The Planning Inspectorate

Your Ref: EN010120

Drax Bio-Energy and Carbon Capture Storage**Deadline 4****Post Hearing Submissions****Landscape****Action Point from ISH3**

PROJECT:	DRAX BECCS DCO				
TITLE:	FIGURE 1 LANDSCAPE AND BIODIVERSITY MITIGATION PLAN

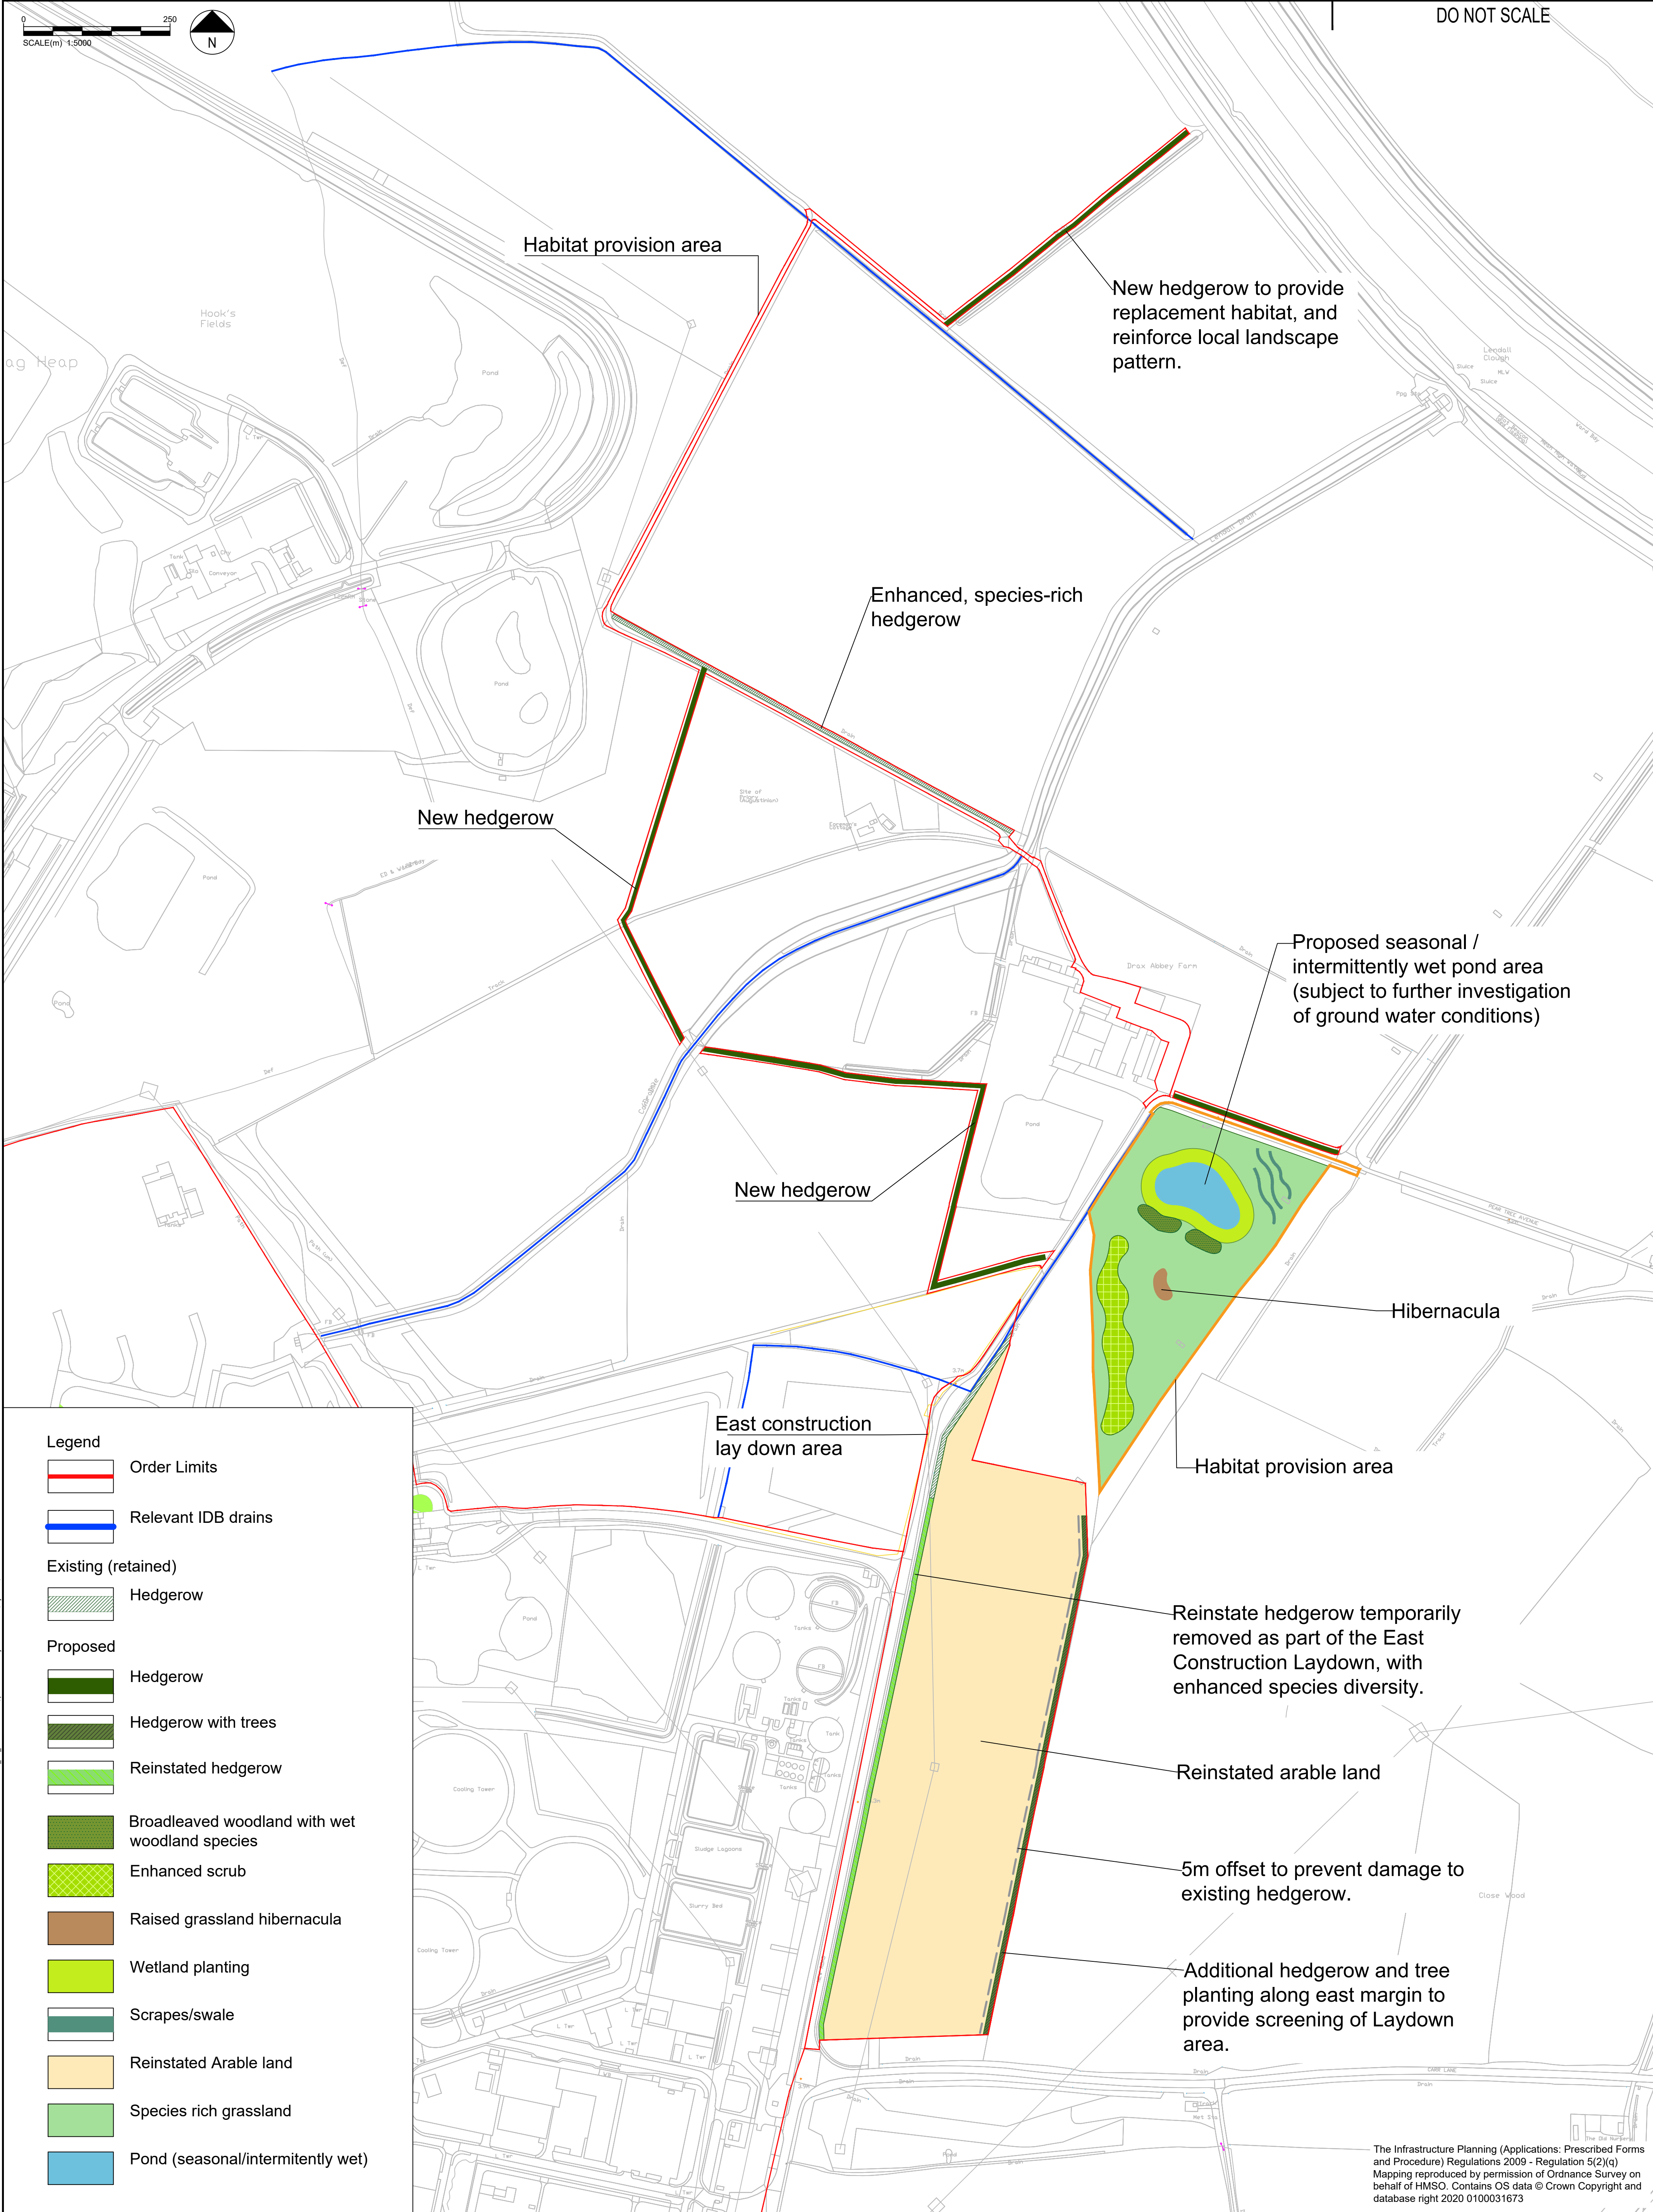
The Outline Landscape and Biodiversity Mitigation plan (fig 1 in the OLBS) needs to include the whole of the Works area and not focus on the Habitat Provision Area. It is a concern to the Authorities that these plans imply that landscape mitigation and design will apply only to the habitat areas.
